Application no: 22/01126/DISC

Location: Land To The South And Adj To, South Side, Steeple Aston

Lead Local Flood Authority

Client	rectory
Project	South Side Steeple Aston
Scale:	1:200 @ A1
Status:	PRELIMINARY
Drawn:	Project Engineer
Checked:	RF
Project No:	6374
Date:	14/05/2021
Drawing Number:	6374-MJA-SW-XX-DR-C-200
Rev:	P4

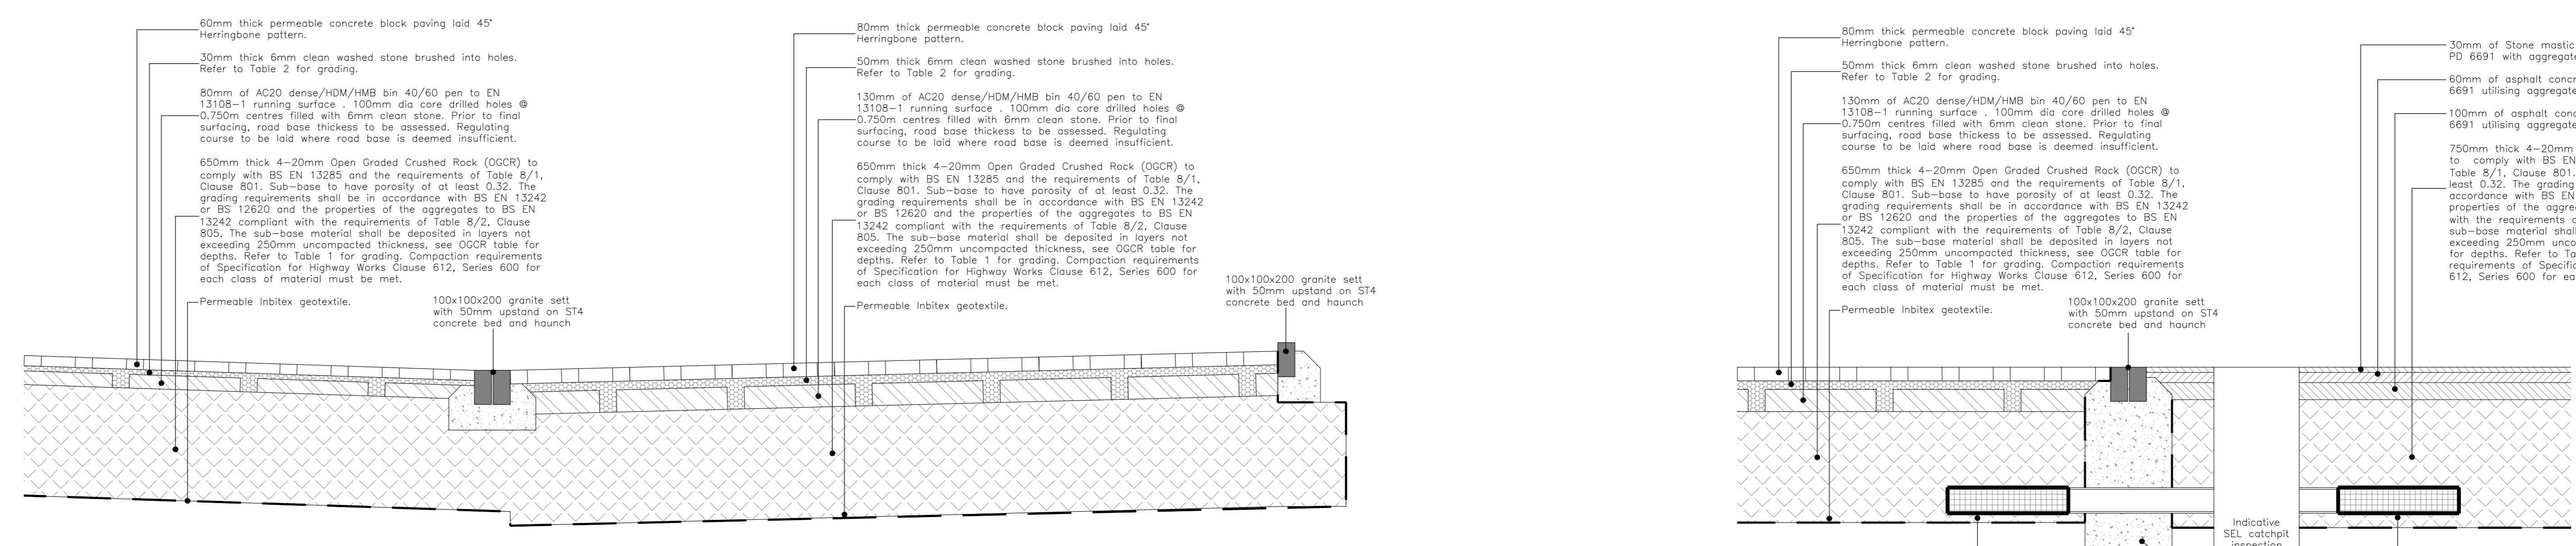
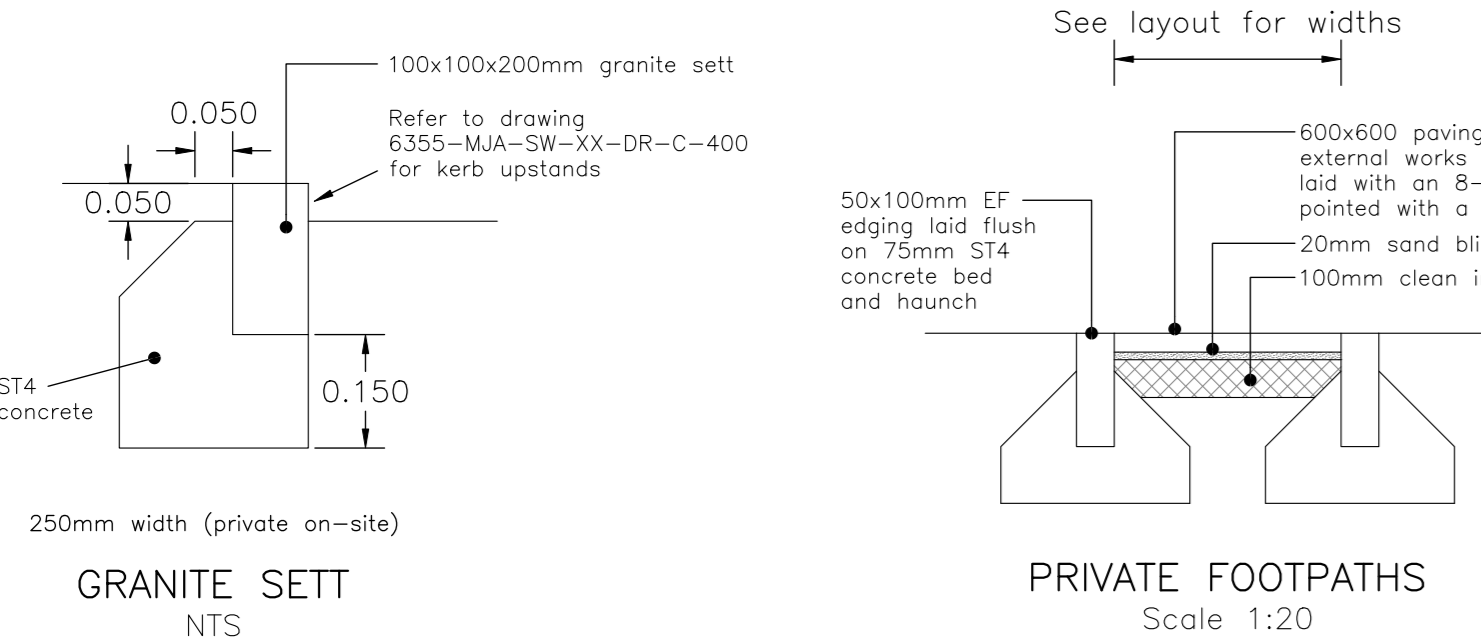
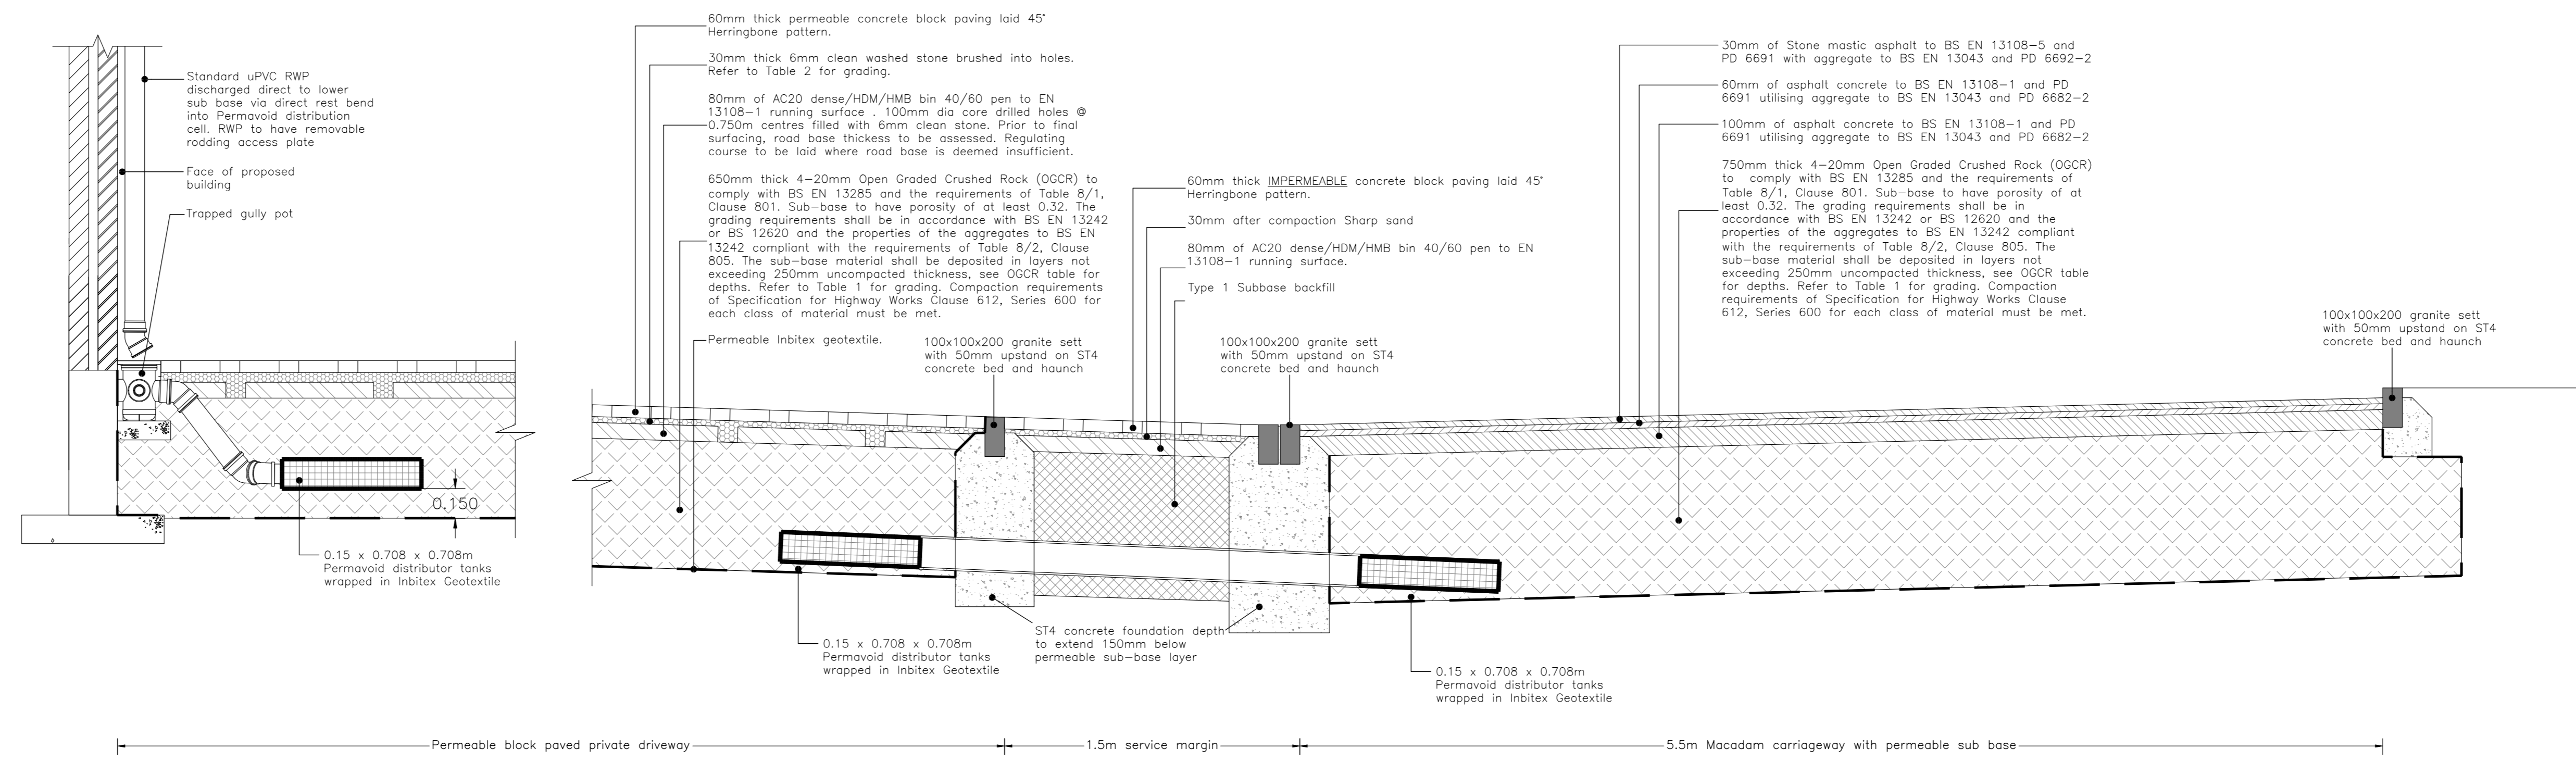
There are no sub base references added to the drainage plan. In order to review and understand the calculations, provide the reference of the sub base on plan.

Provide the storage area and sub base thickness on the drainage plan in order to review the calculations and ensure the design is consistent.
